re: Geotechnical Review – Grading Plan
Proposed commercial Development
30 Frank Nighbor Place - Kanata, ontario

date: September 9, 2022

file: PG6153-MEMO.01

**DRAWING NAME**  
GRADING AND EROSION & SEDIMENT CONTROL PLAN

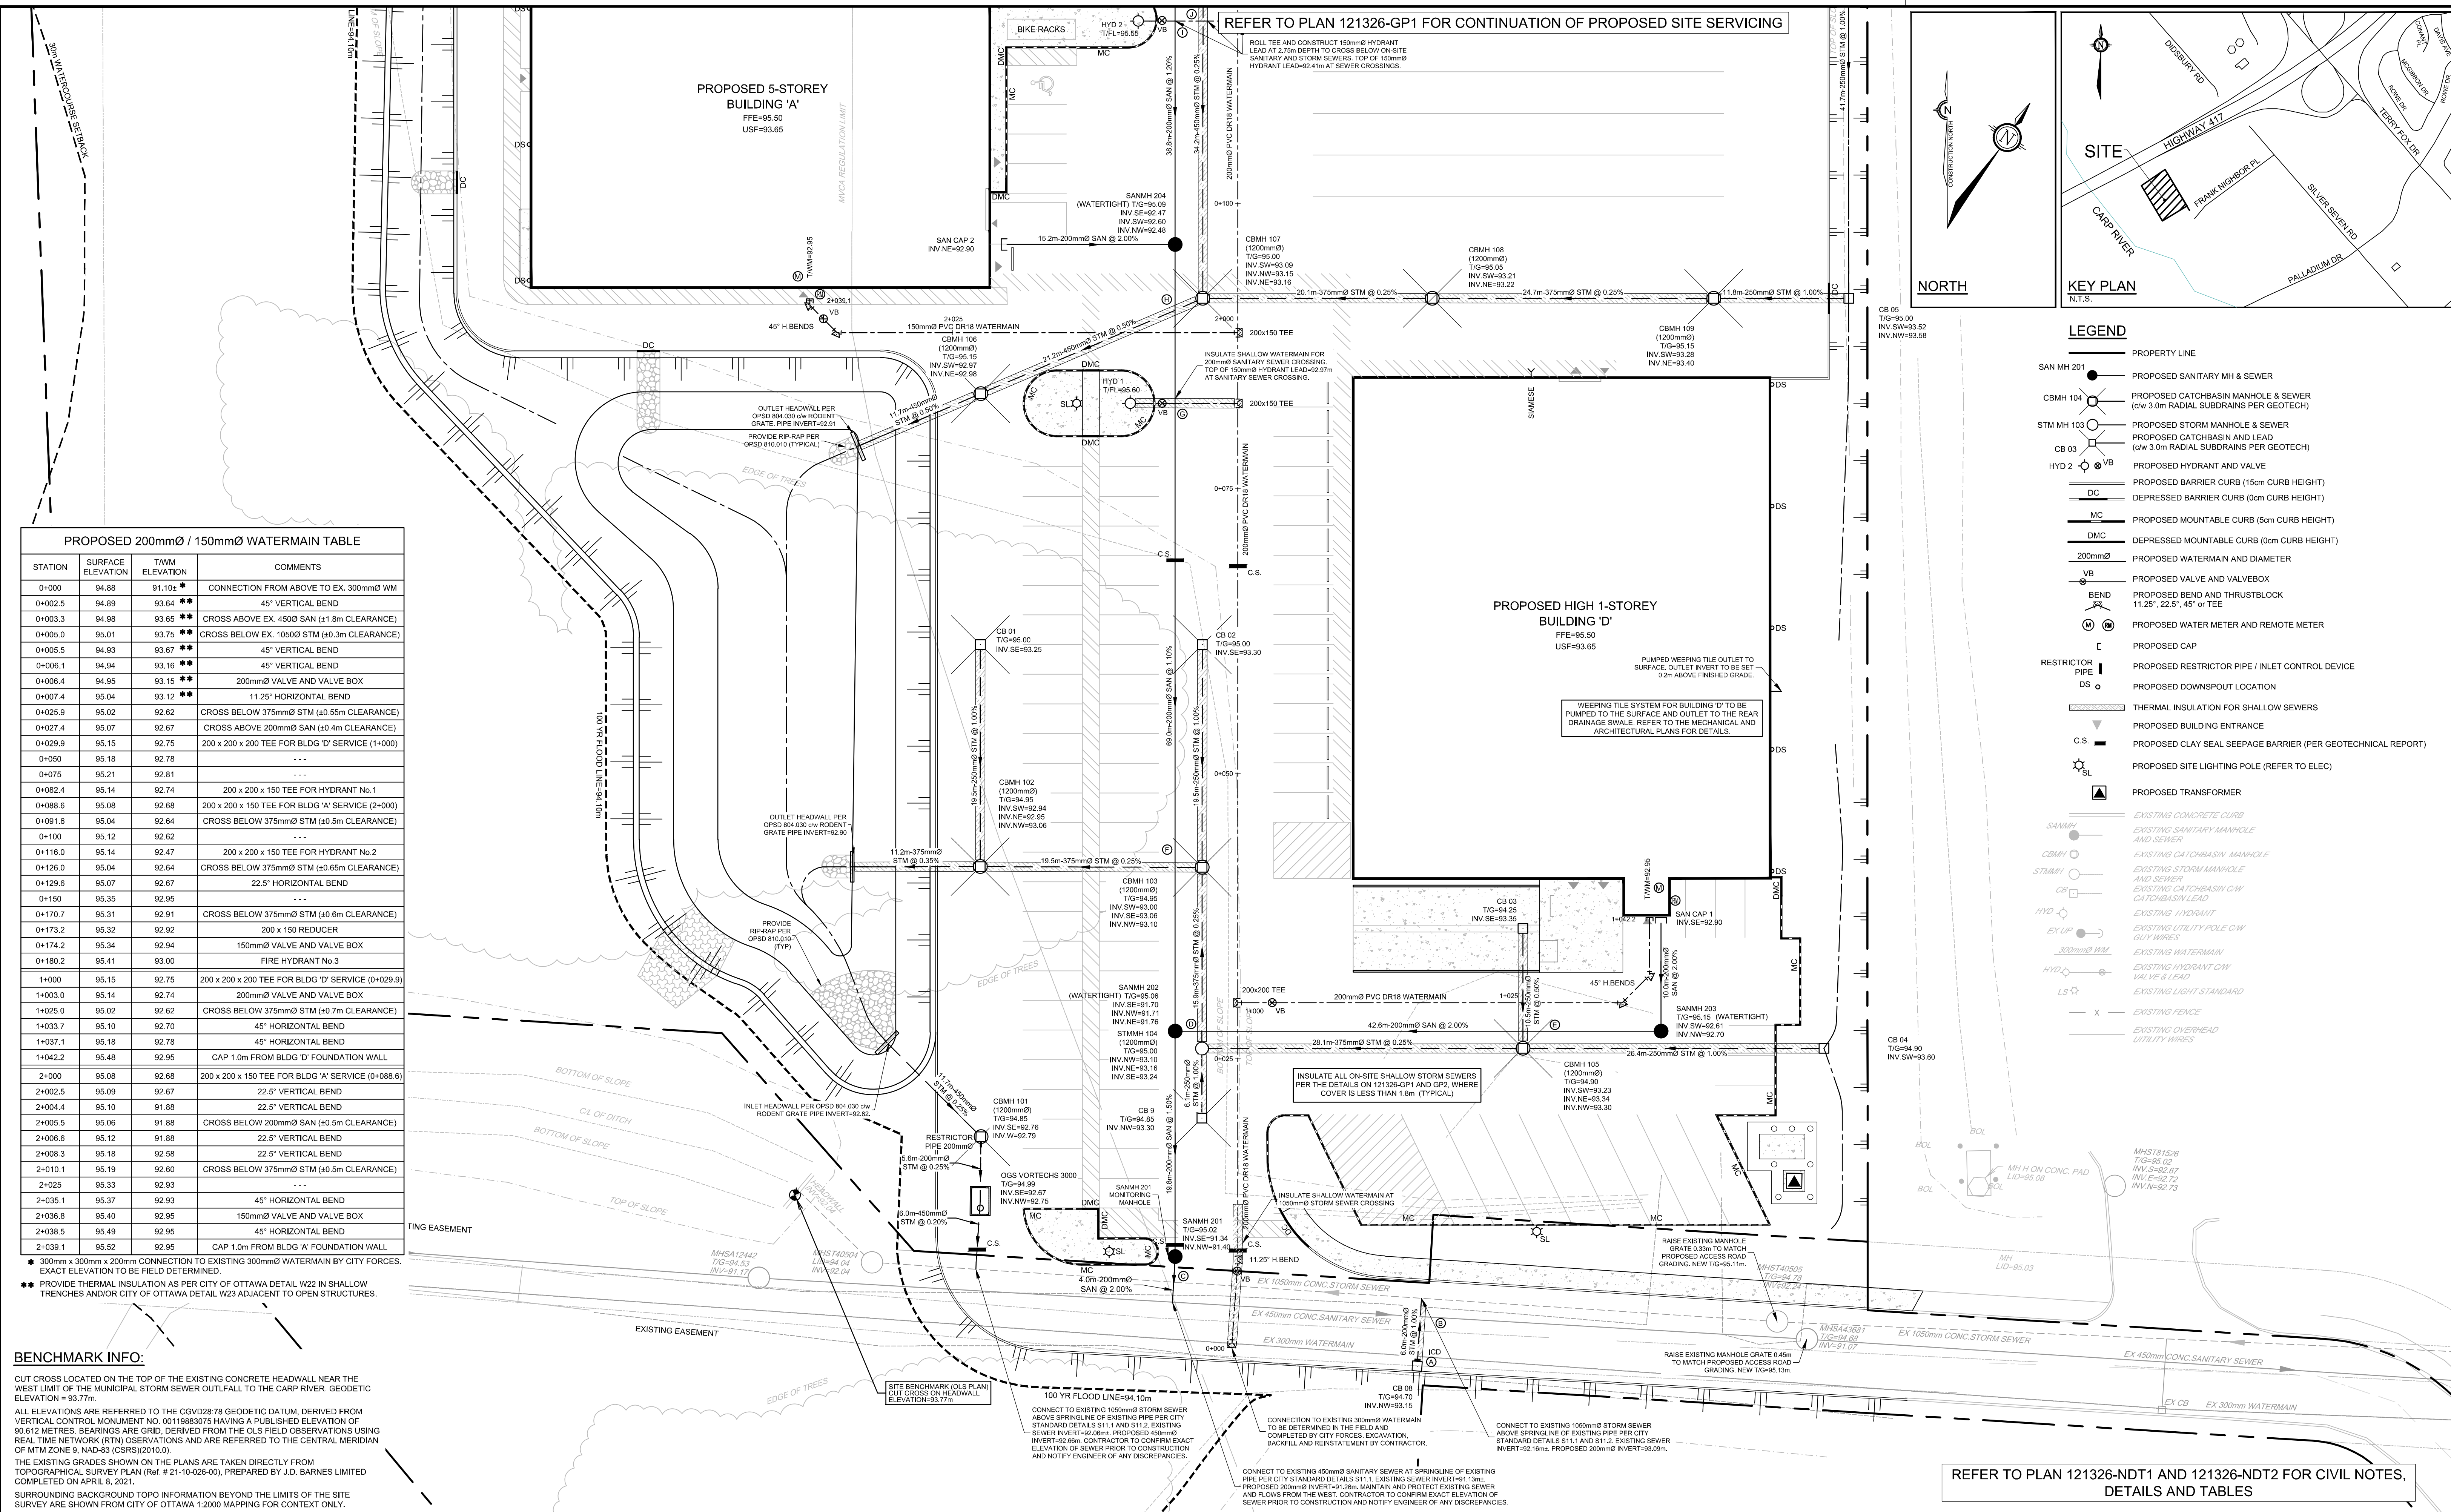
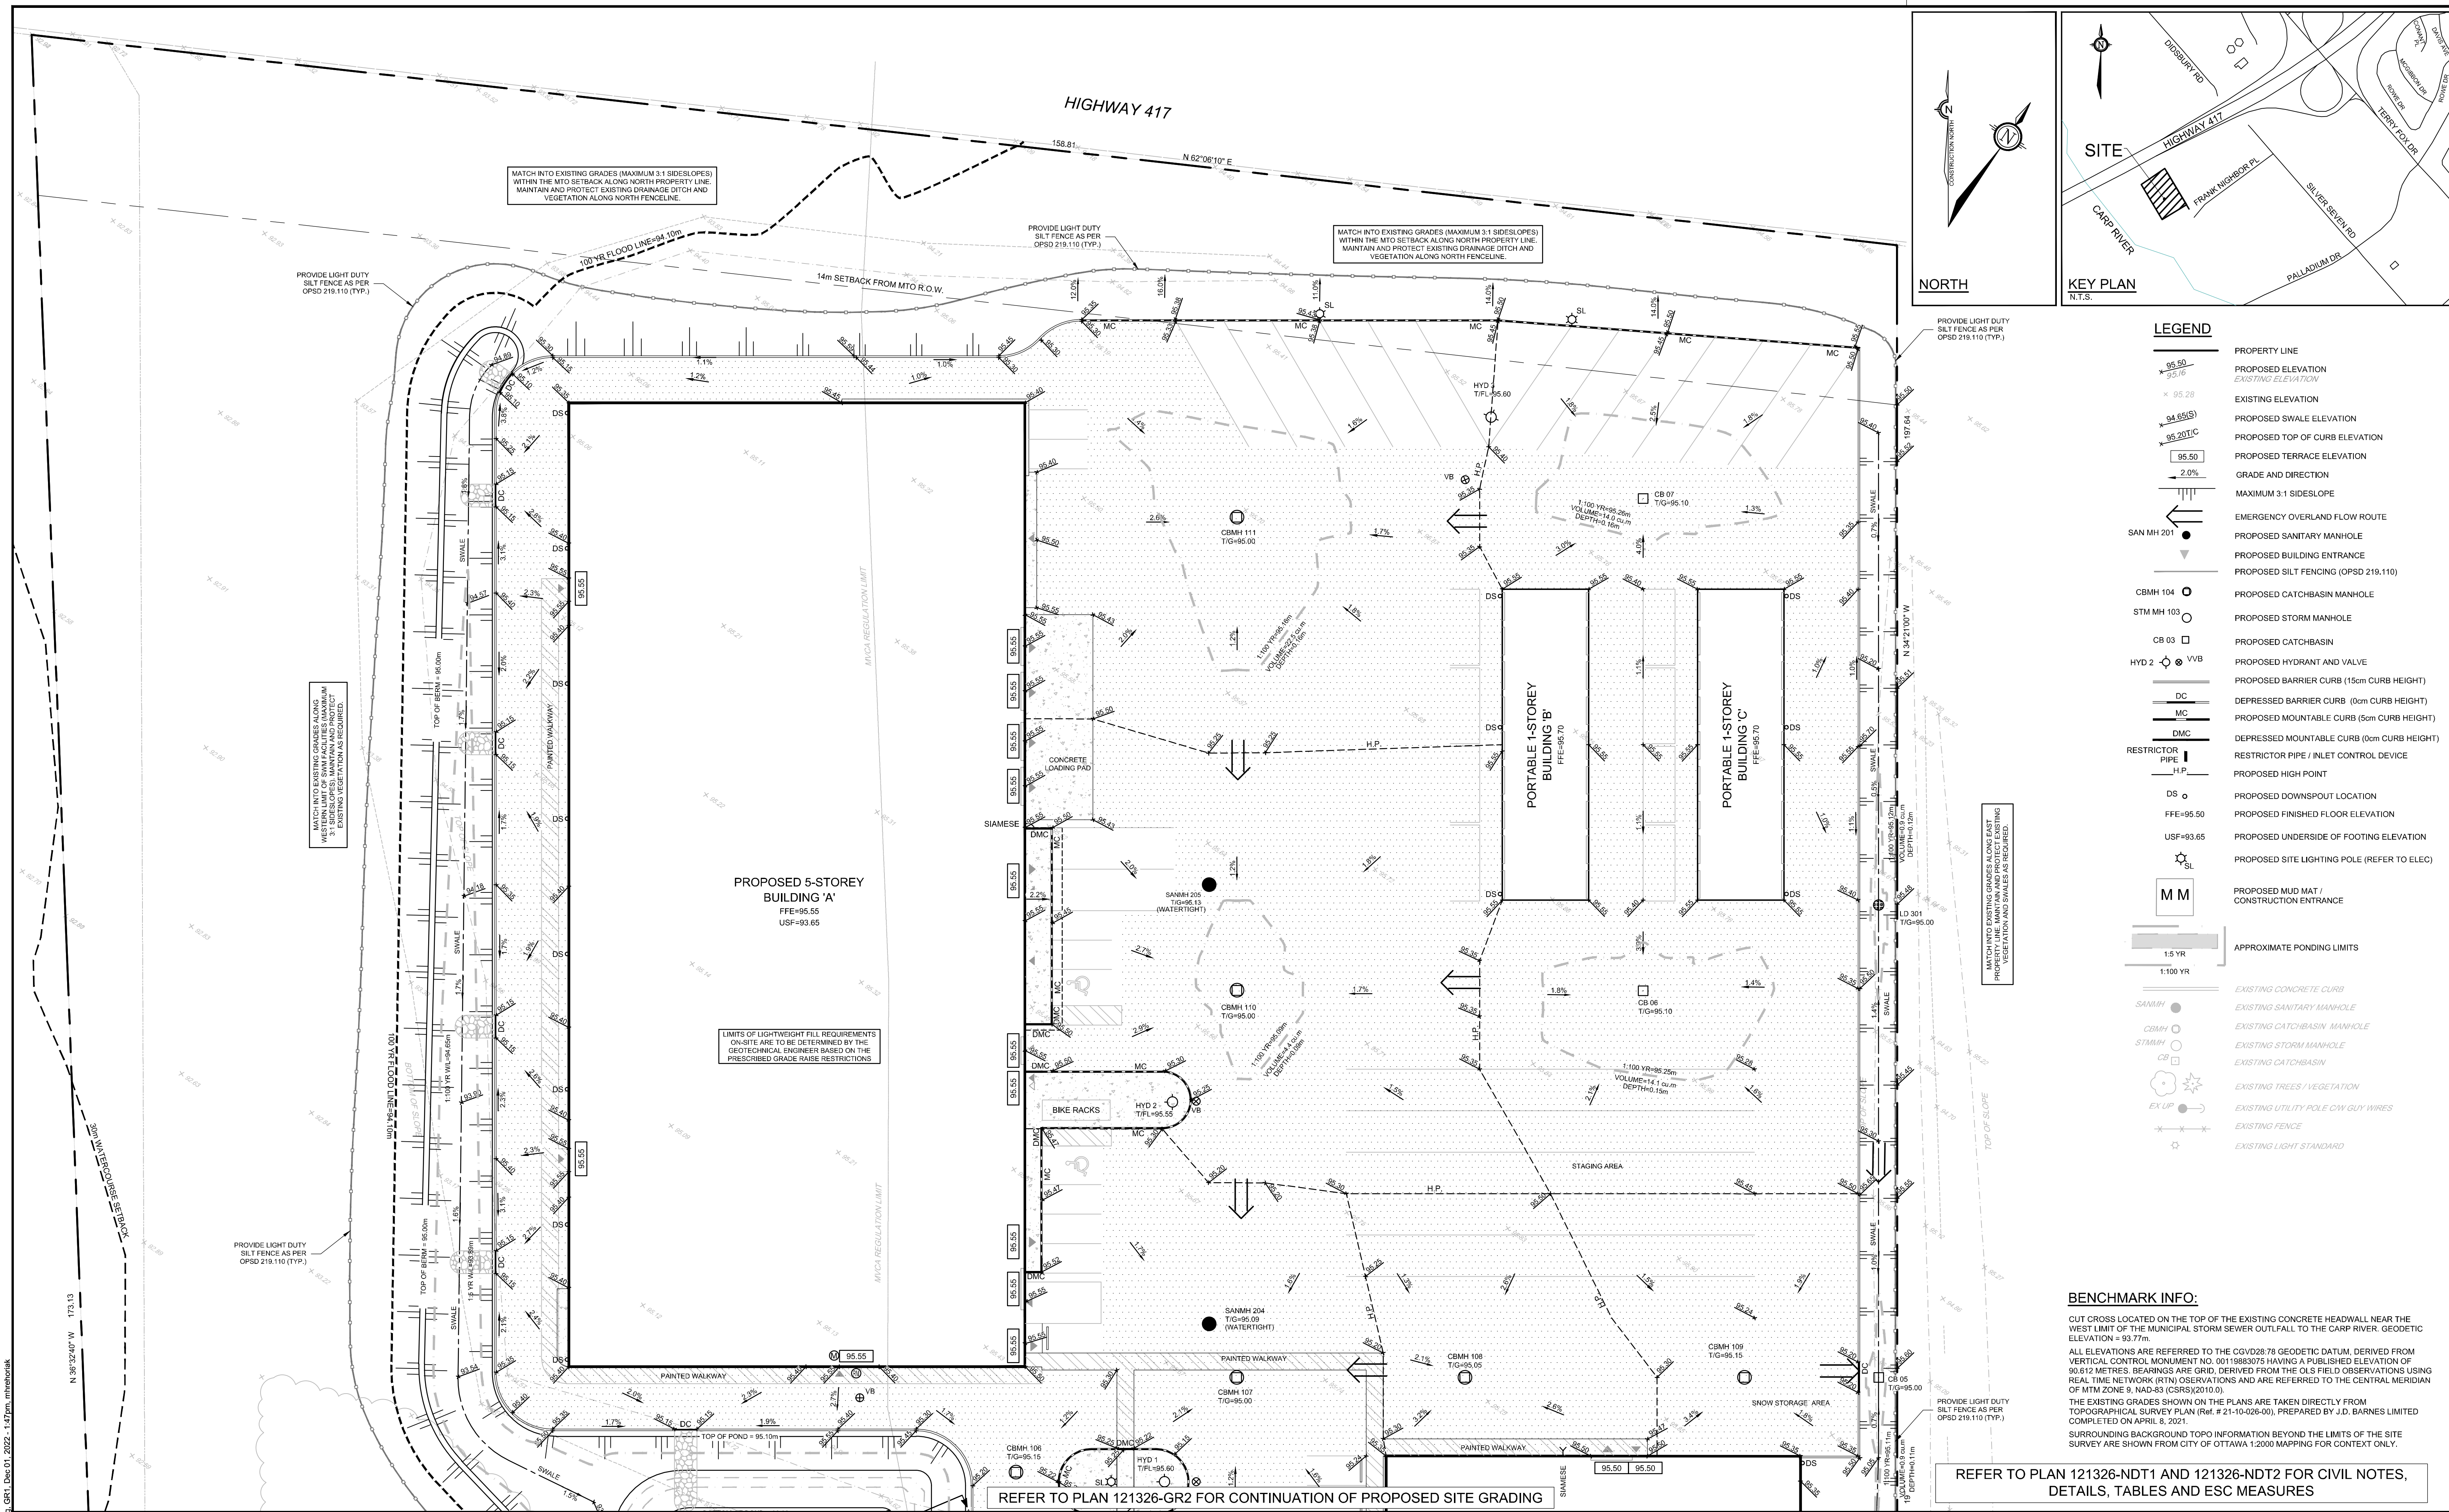
- Project No. 121326 - Drawings No. 121326-GR1 Revision 2 – Grading and Erosion & Sediment Control Plan dated August 30, 2022.
- Project No. 121326 - Drawings No. 121326-GR2 Revision 2 – Grading and Erosion & Sediment Control Plan dated August 30, 2022.

Based on our review of the above noted drawing, the proposed grading for the portable buildings B, C and D meets our recommended permissible grade raise recommendations provided in the geotechnical report. Therefore, no lightweight fill is required for the buildings B, C and D. However, Building A exceeds the permissible grade raise recommendations. Our grading summary and lightweight fill recommendations are presented in Table 1 – Soil Matrix Summary attached

The LWF material should consists of EPS 19 under the slab on grade, EPS 12 around the reminder of foundation under landscaped area and EPS 15 should be used below paved areas. The LWF should be placed against the foundation wall, above the footing and a minimum of 300 mm below the finish surface. The LWF EPS blocks should extend a minimum of 2.4 m outside the foundation wall with the thicknesses recommended in the attached Table 1.
